Harnett County Government Complex
307 Cornelius Harnett Boulevard
Lillington, NC 27546

RE: Status of Existing Tank Permit Application #06-5-15706

SITE PLAN APPROVAL  
DISTRICT R20R USE POOL  
#BEDROOMS N/A 9/7/06  
[Signature] ZONING ADMINISTRATOR  
9-7-06

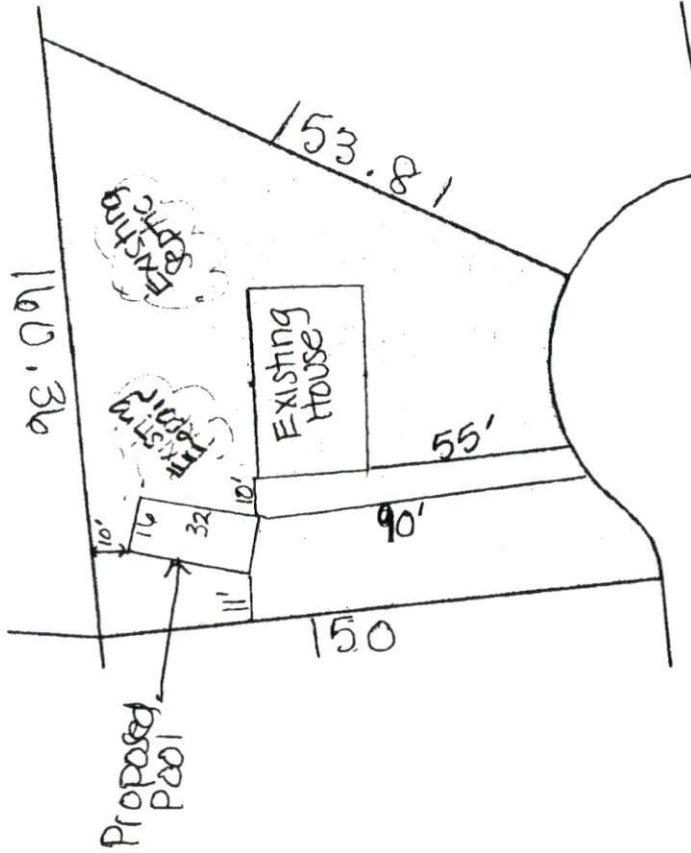
- 1. Uncover outlet lid on septic tank and break seal
- 2. Have system pumped out
- 3. Replace sanitary T
- 4. Other Pool will be on top of repair area and cannot be approved that way. Please go to Central Permitting and fill out soil evaluation (fees will need to be paid) so I will be able to locate another possible repair site on this property. Please mark property lines and have all underground utilities marked before I come out.
